From: Richard Goodall <[REDACTED]>
Sent: 26 August 2021 08:54
To: Simon Davis
Subject: Re: P/117/21/PL Sefter Farm

client BARFOOTS OF BOTLEY LTD			
project SEFTER EAST Proposed New Packhouse & Car Park Relocation			
title Location Plan			
date July 2021	scale @ A3 1:2500	drawn GBC	chkd GBC
project no. 2102	drawing no. 001	rev 02

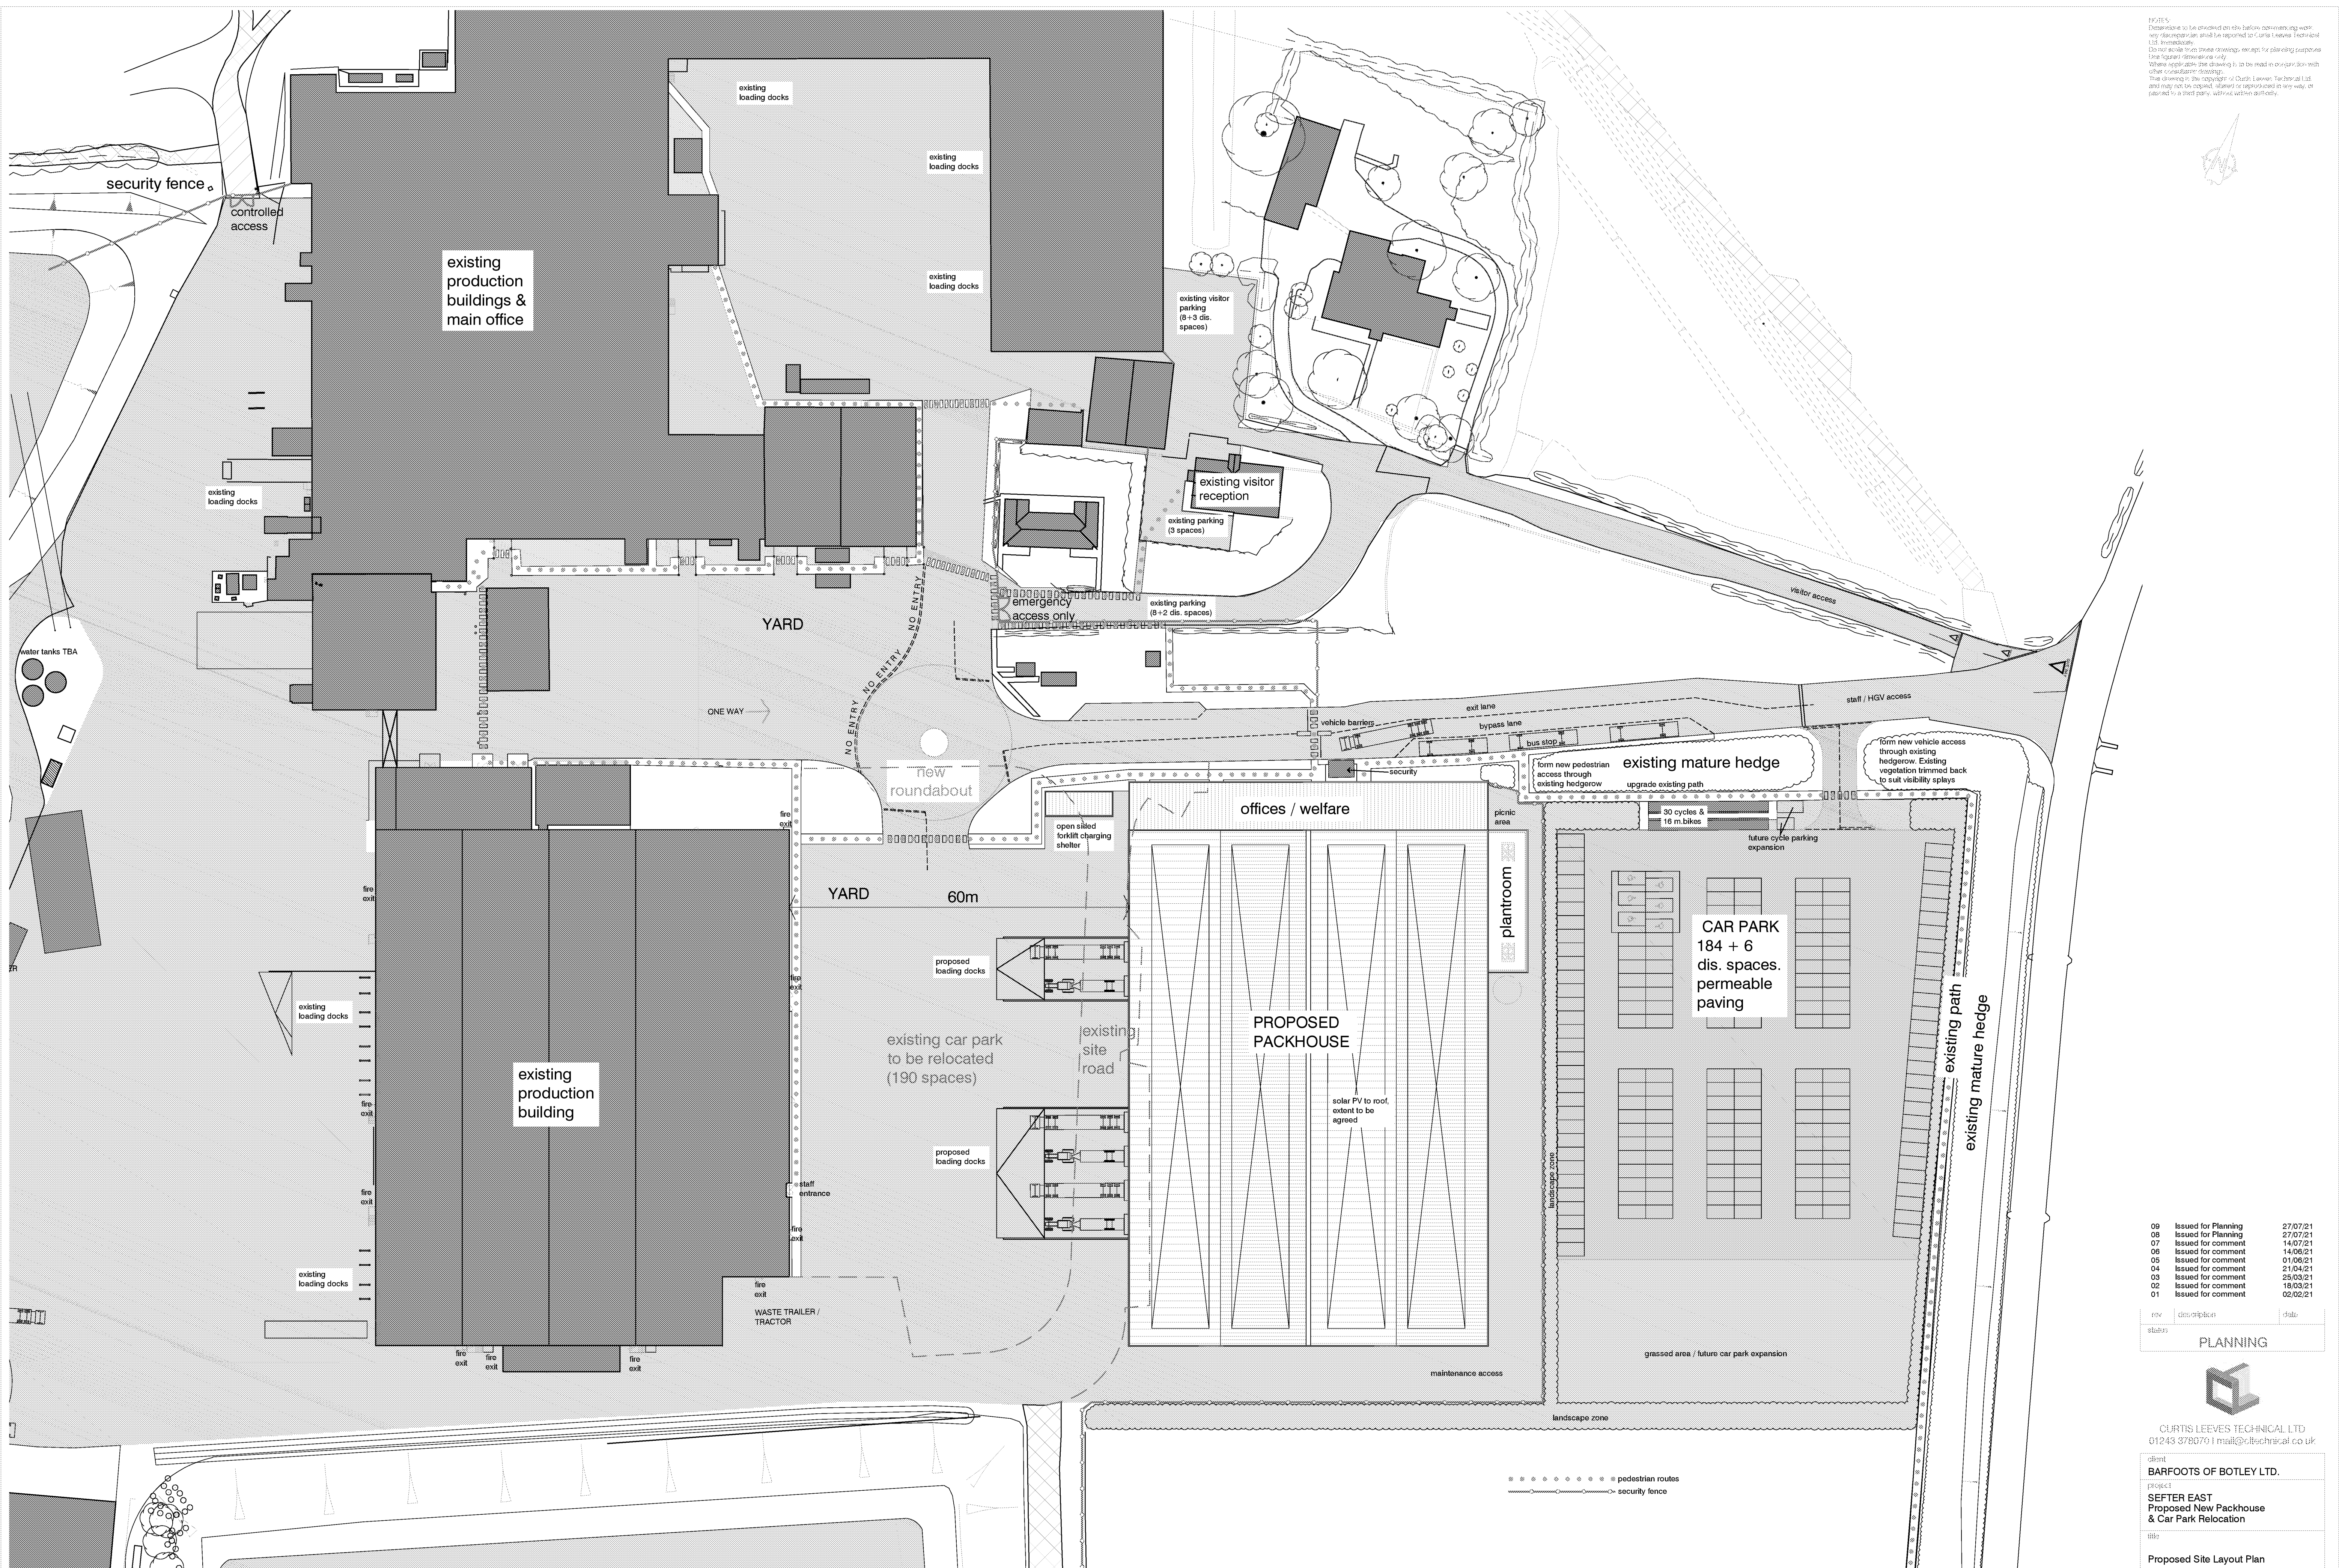
I note that you say in your planning statement that *The proposed building will be located on the existing staff parking area and clearly this will need to be relocated. A new parking area is therefore proposed on land between the proposed new building and Pagham Road immediately to the south of the existing site access.*

I understand this but the proposed site plan suggests that the packhouse will not actually be on the existing car park, touching/affecting it yes but actually sited east of it so this is a little misleading. It would also help if the proposed site plan was annotated to say "new service yard area on existing staff car park" (or similar) as opposed to "existing car park to be relocated (190 spaces)". My worry is that local people will compare the existing & proposed plans and think that there will be two car parks, one relocated and one new (as I did – before I then read the planning statement which local persons may not do).

an amended site plan as requested.

With hindsight it could have been clearer. Hopefully this addresses the issue raised.
